DRB Application No.: 07DRB-00139 (P&F)
Project Name LEONARD INDUSTRIAL
Agent: JACK'S HIGH COUNTRY

Project # 1005335
Phone No.: 898-3707

RE: Lot E-1, Leonard Industrial Area/minor plat

RE: Tract E-1, Leonard Industrial Area/sketch

**PLAT OF  
LOTS E-1-A AND E-1-B  
LEONARD INDUSTRIAL AREA**

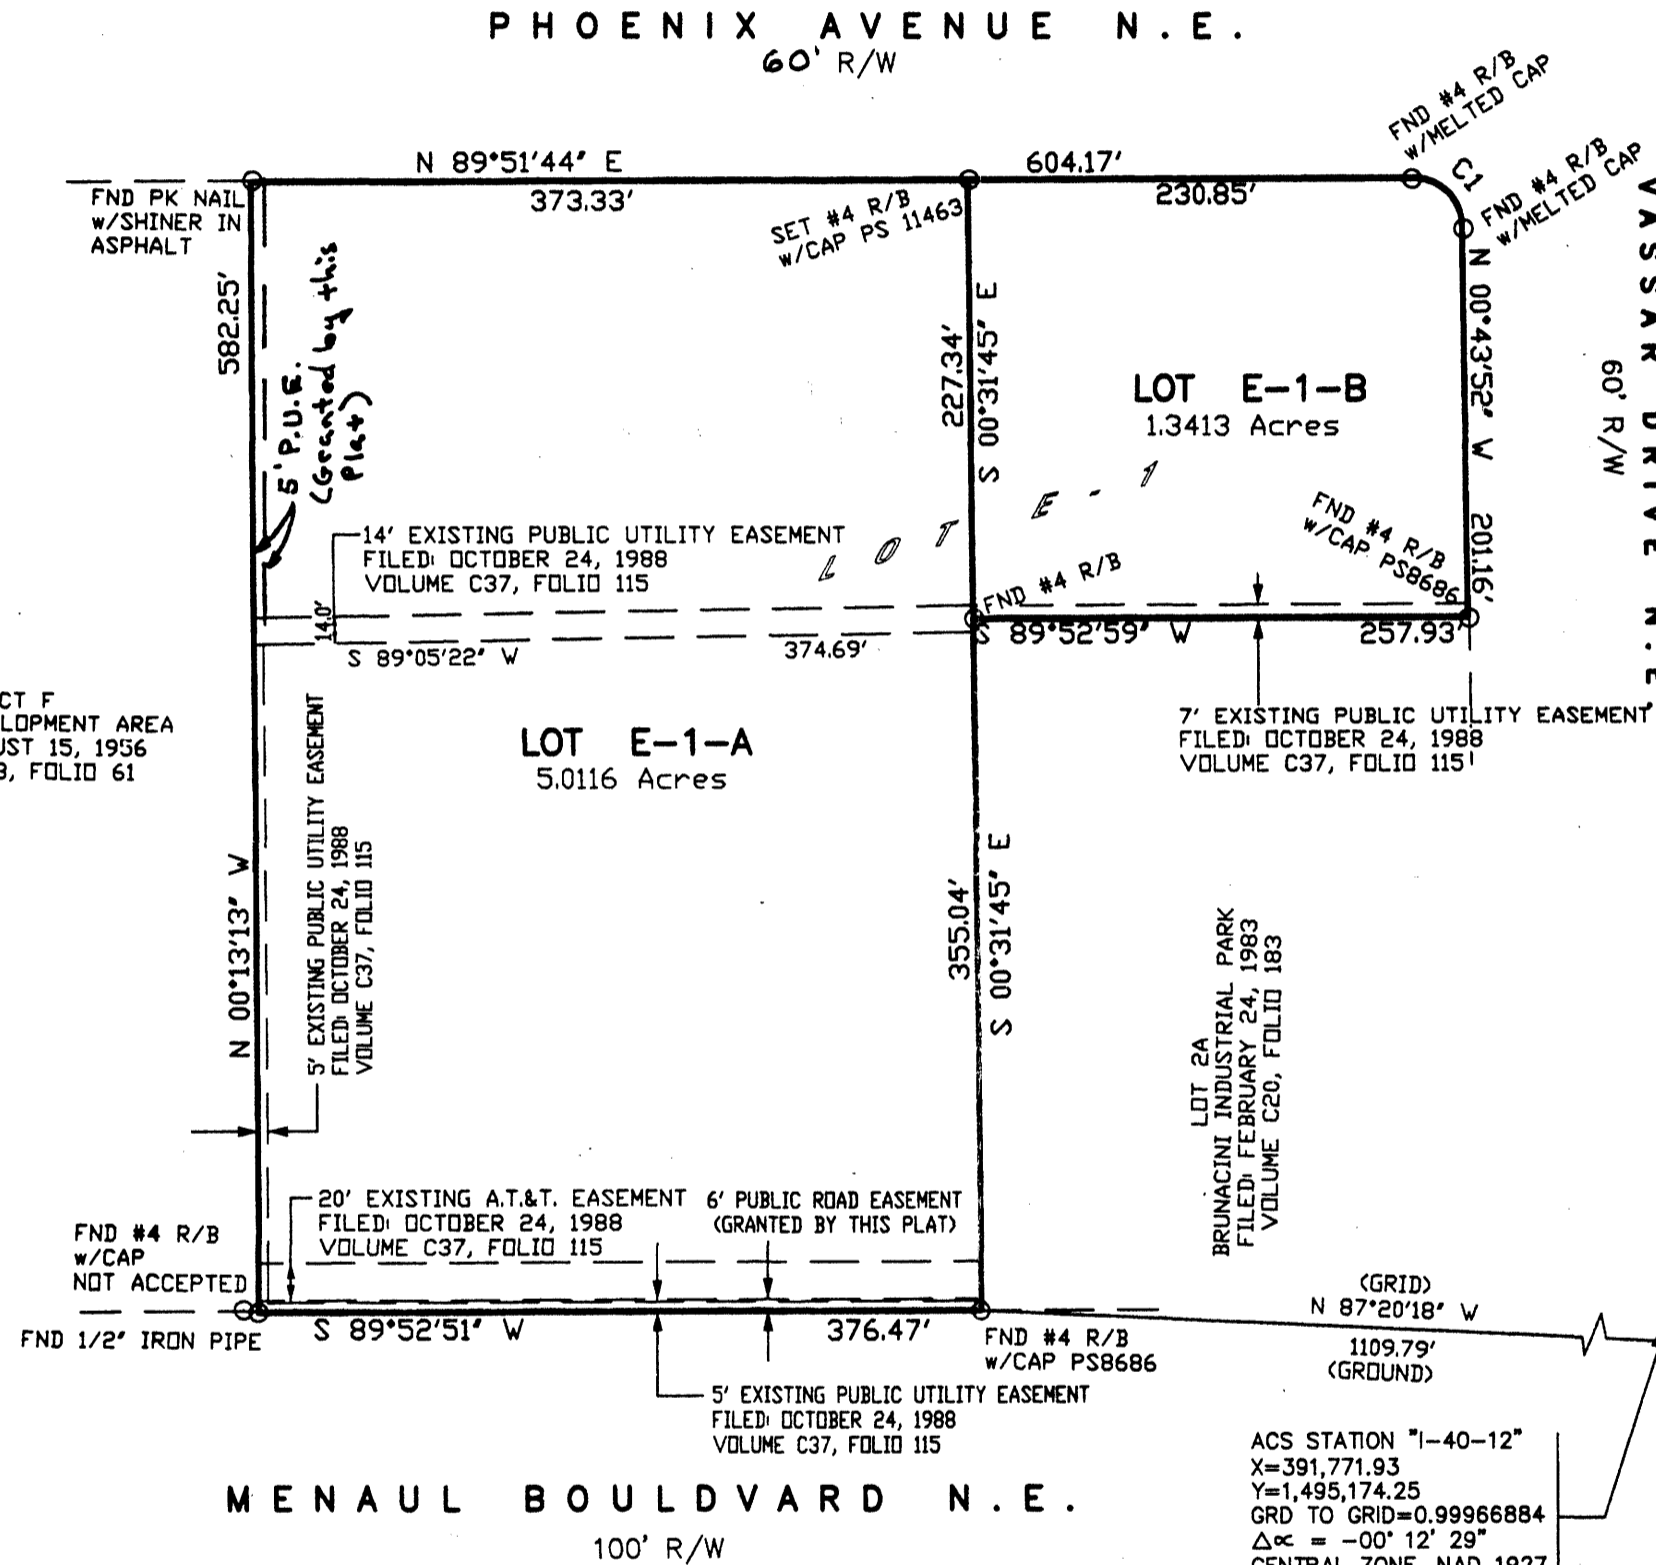
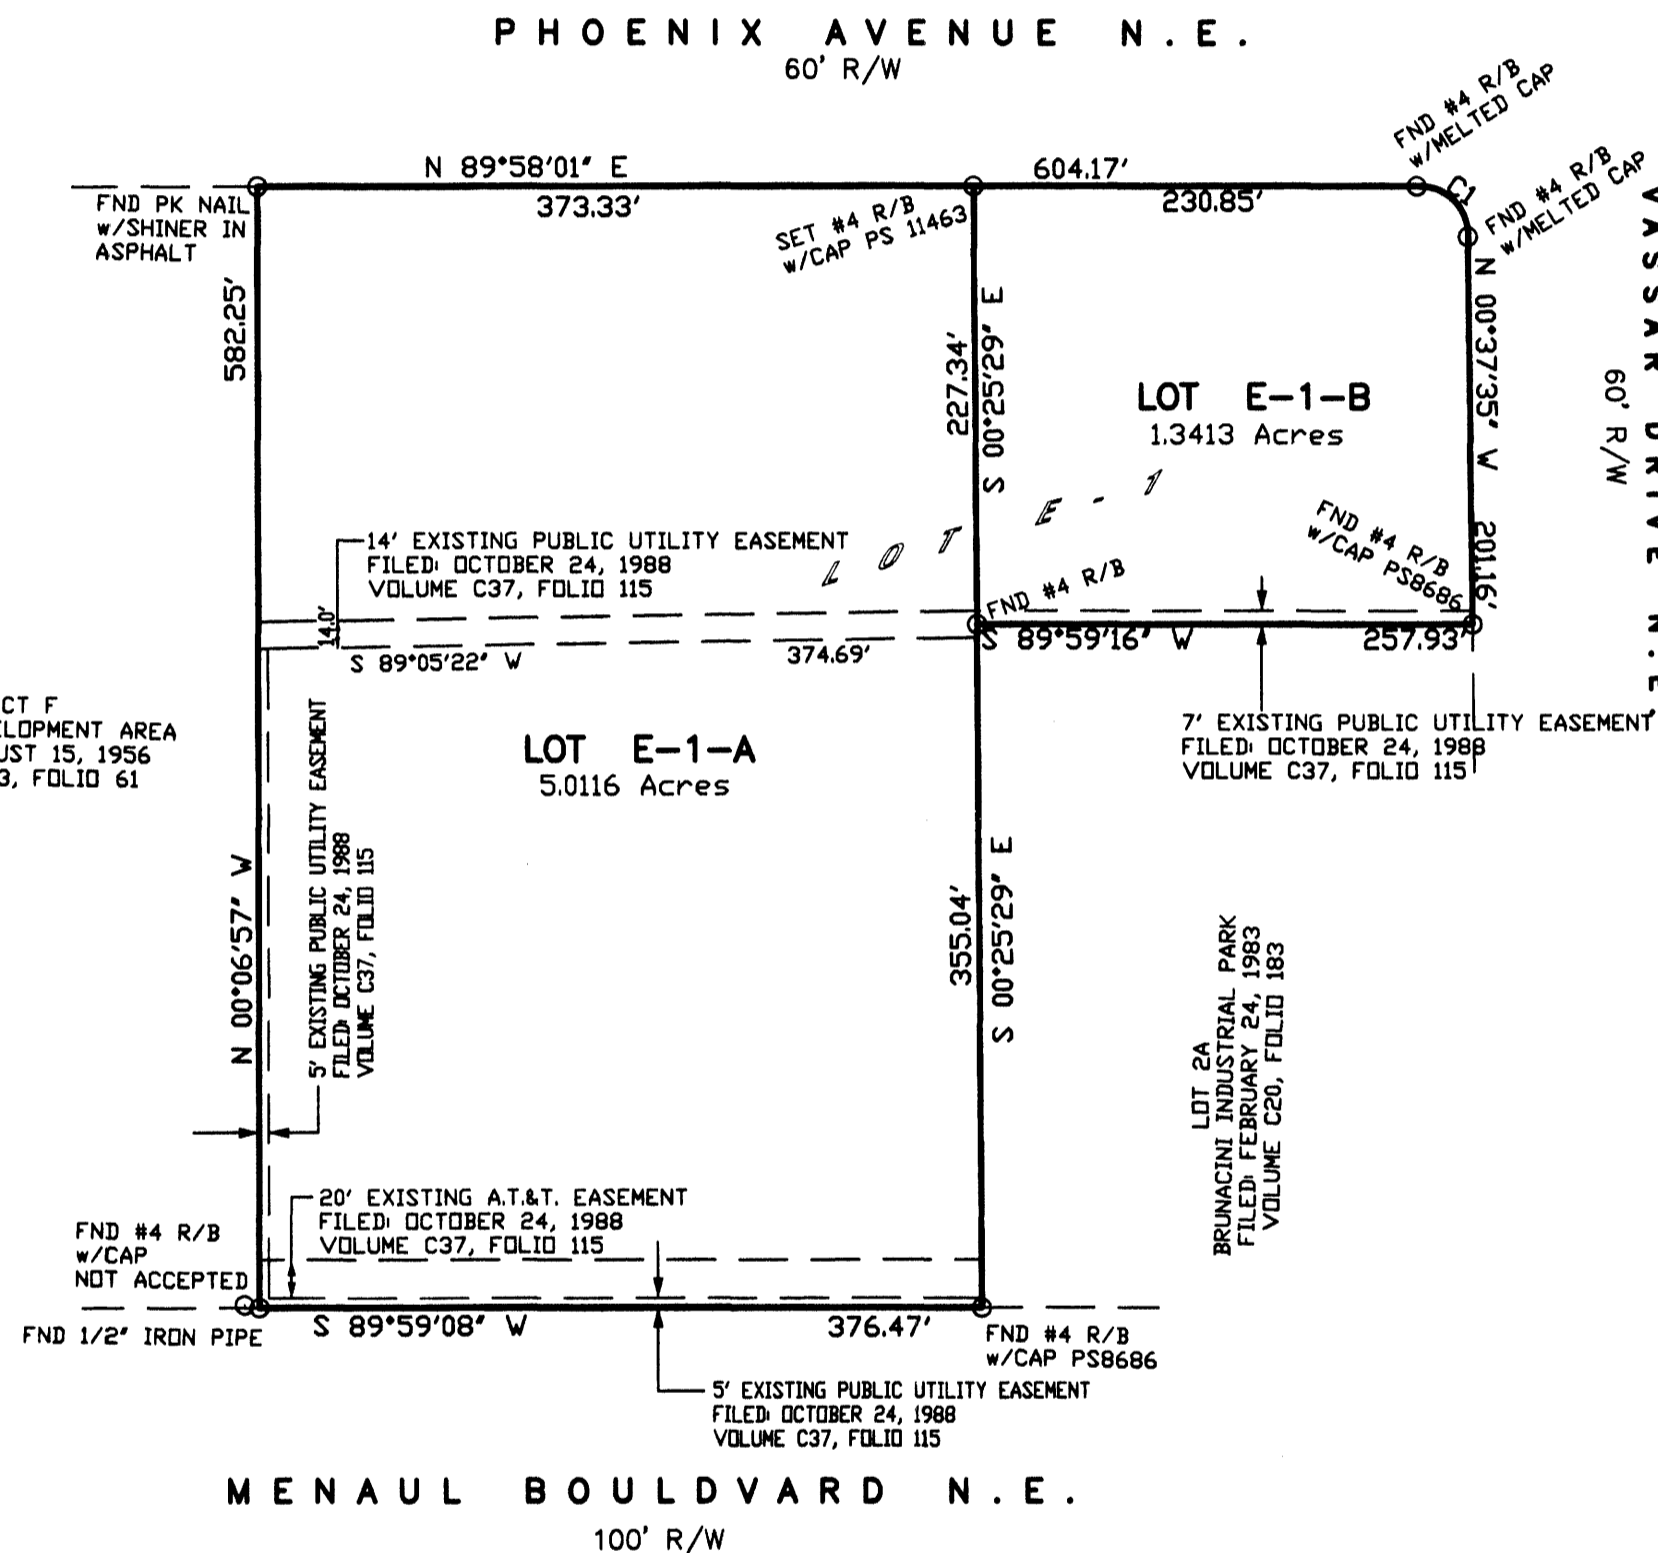
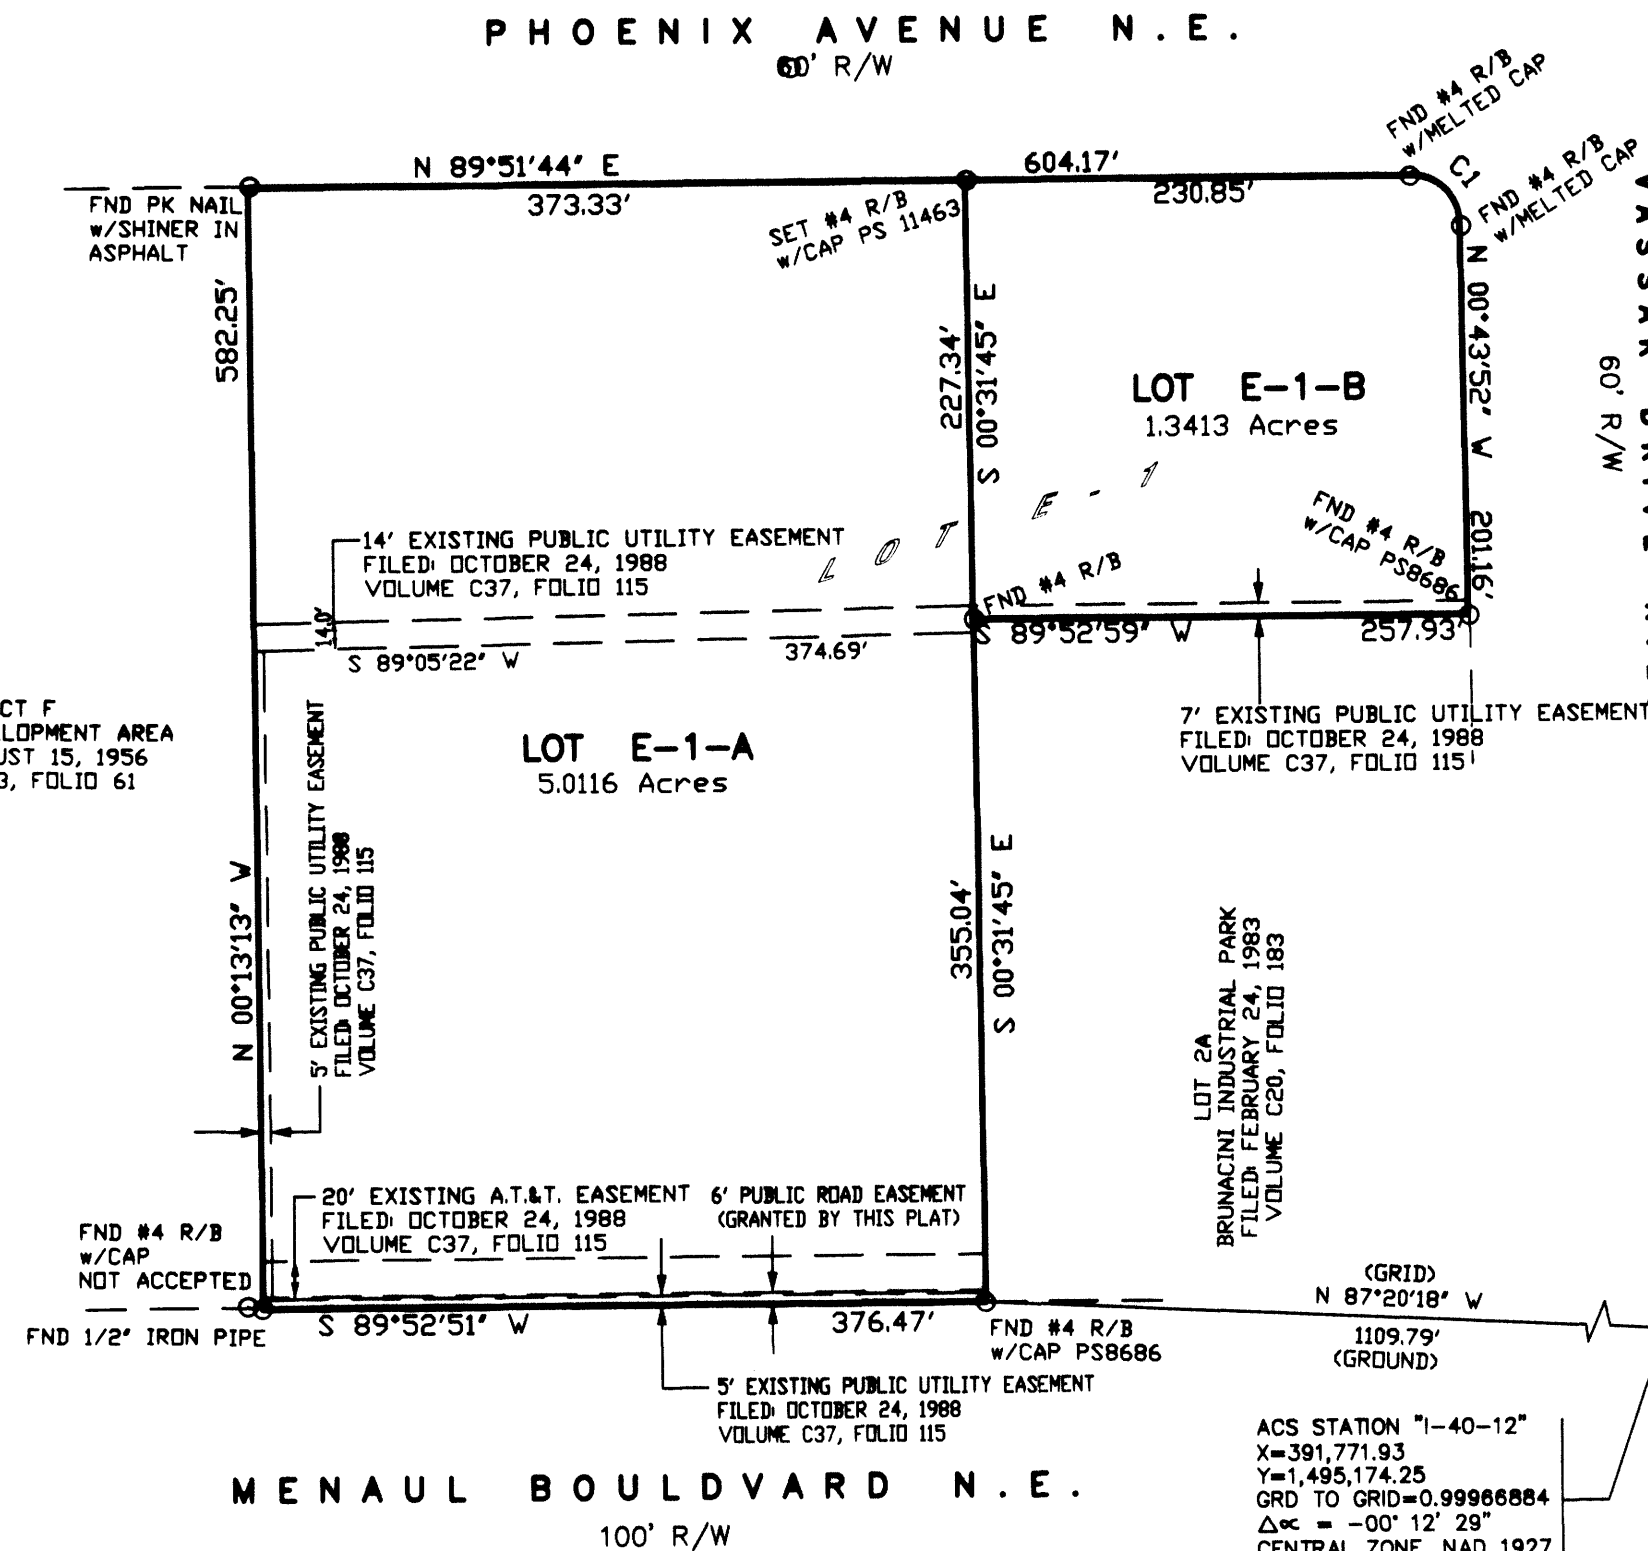
Will a cross lot drainage easement be required?

- 1) What are the distances from face of curb to the property lines? What are the sidewalk widths and their locations?
- 2) Menaul is a principal arterial and may require a 124' right-of-way.
